ENG-SF18027-2024R1 - CDs.pdf Markup Summary

Subject:
Page Index: 1
Date: 3/26/2024 10:46:08 AM
Author: Jeff Rice - EPC Engineering Review
Color: 
Layer:
Space:
Page Label: [1] Layout1

SECTION A TYPICAL EMBANKMENT WITH SOIL KEYWAY
SCALE: N.T.S.

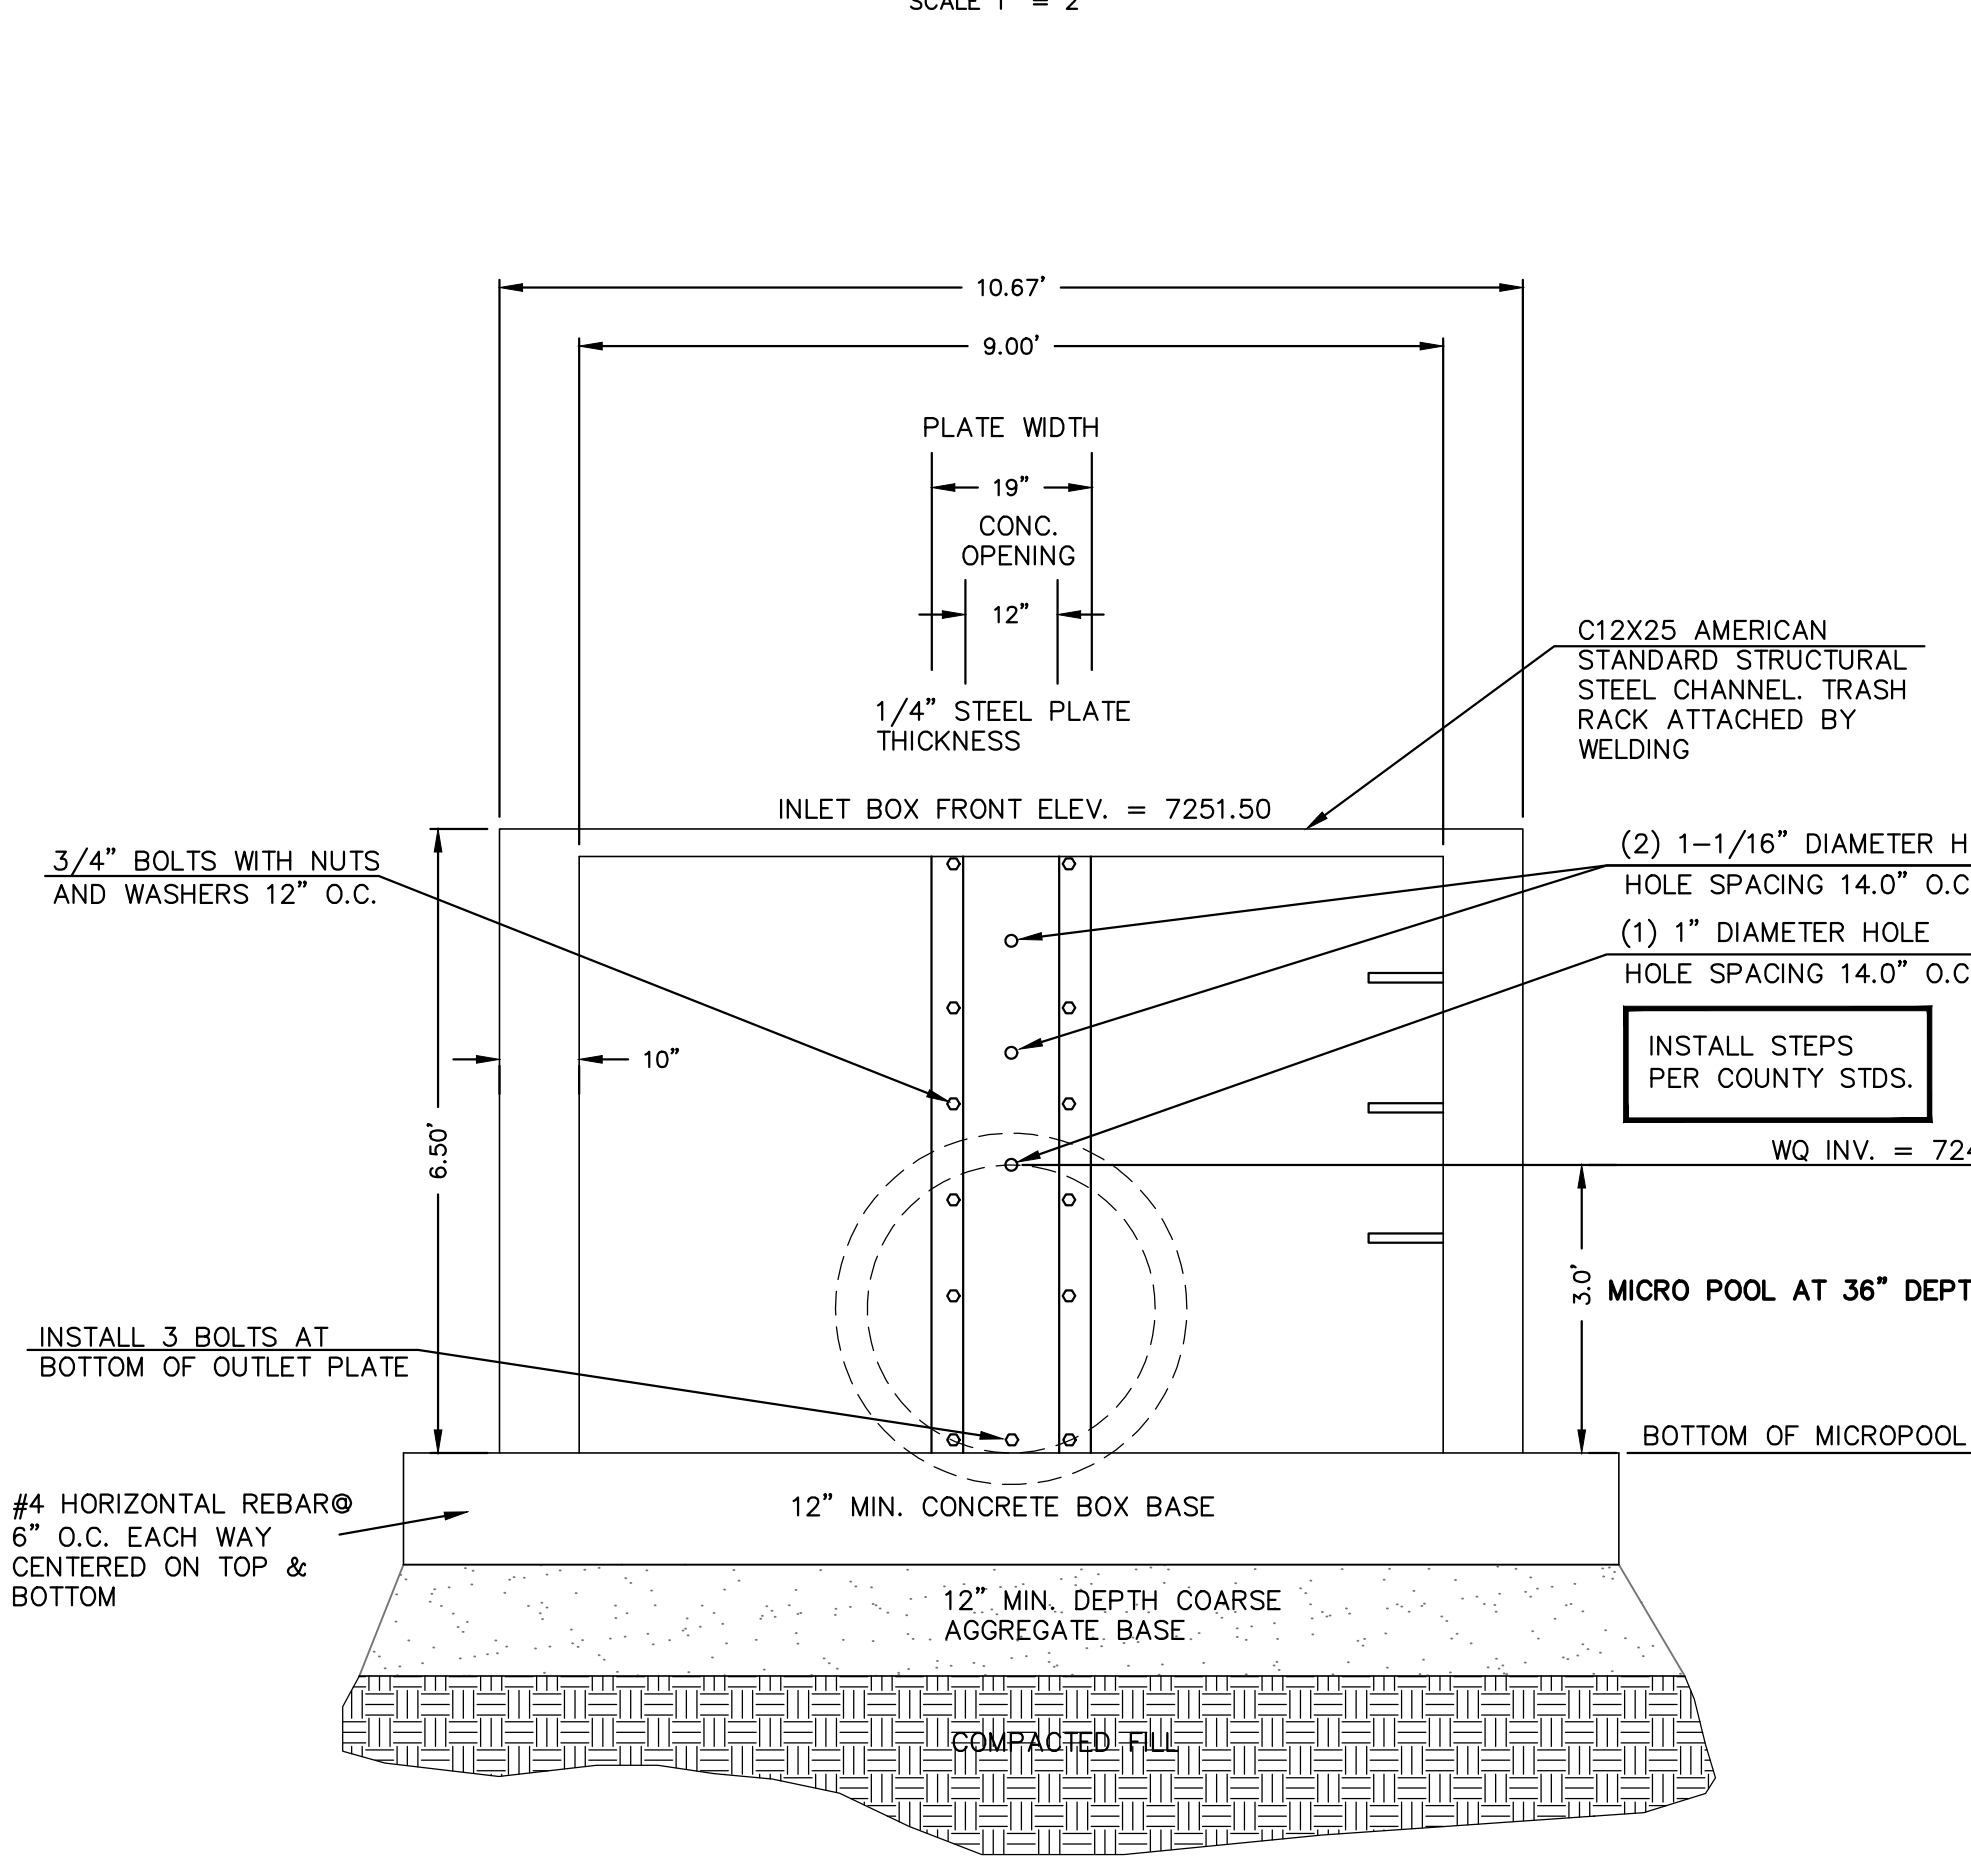
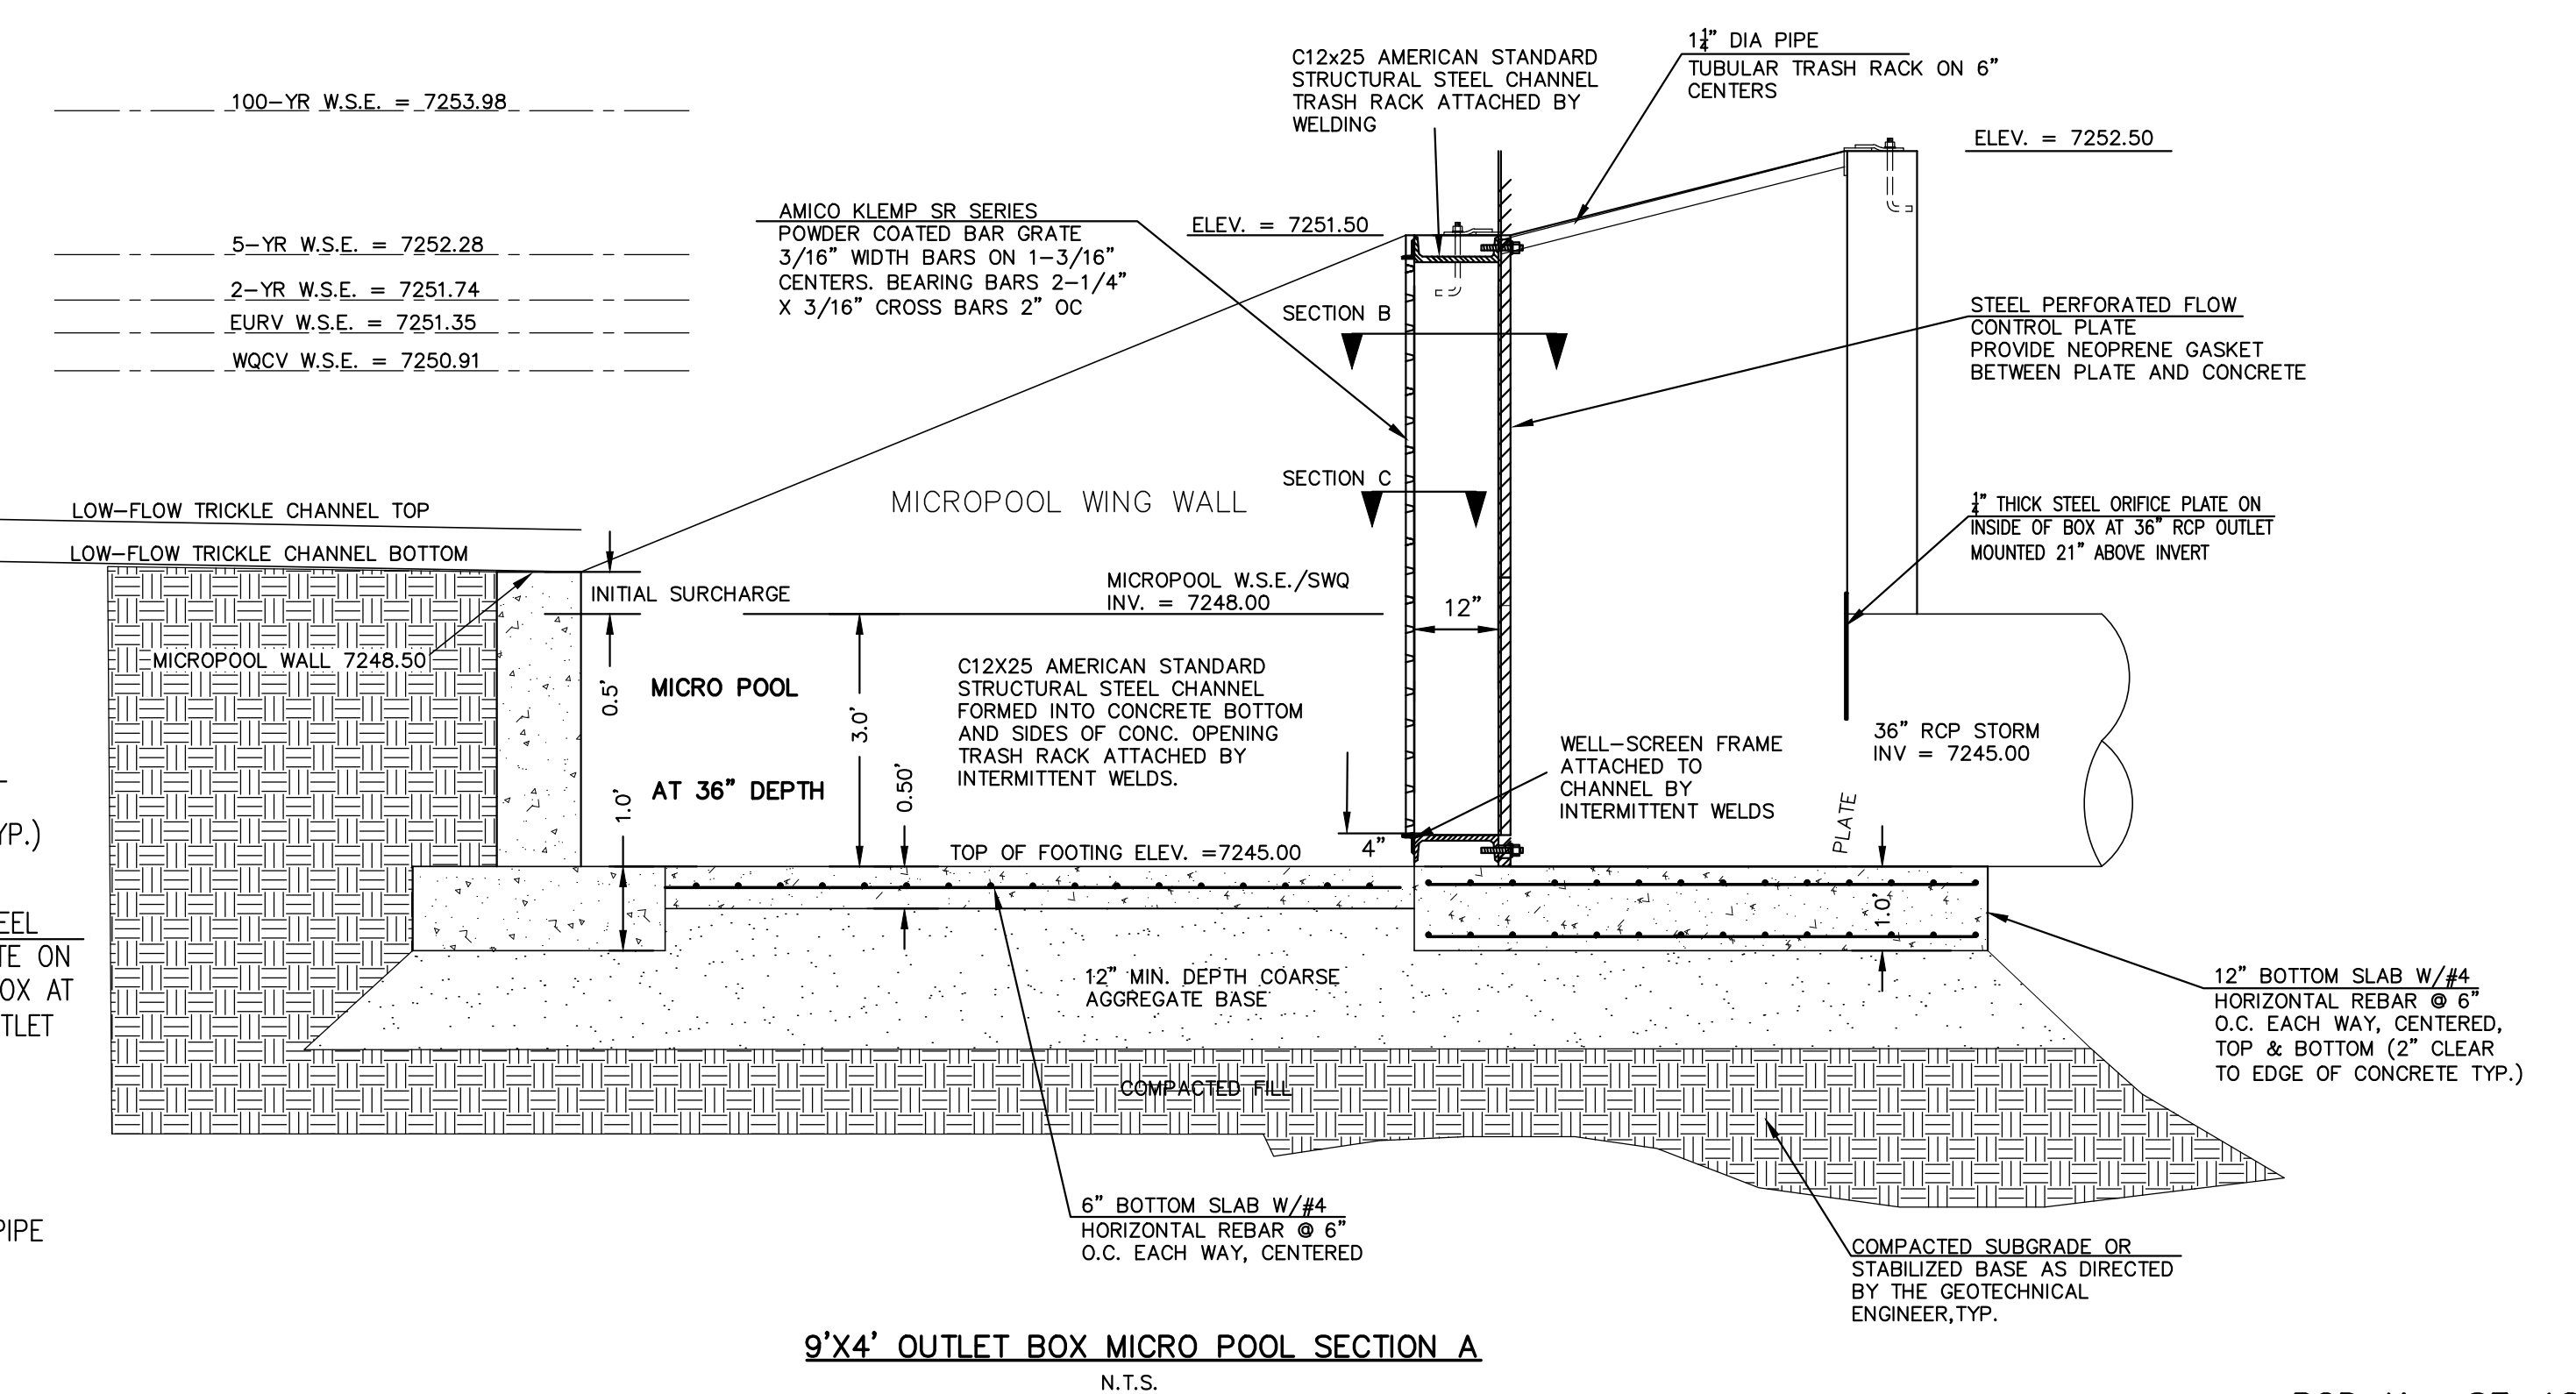
Show and label outlet protection

Label outlet protection

Label slope. Is protection needed with this steep of a slope?

See sheet XX for pond details
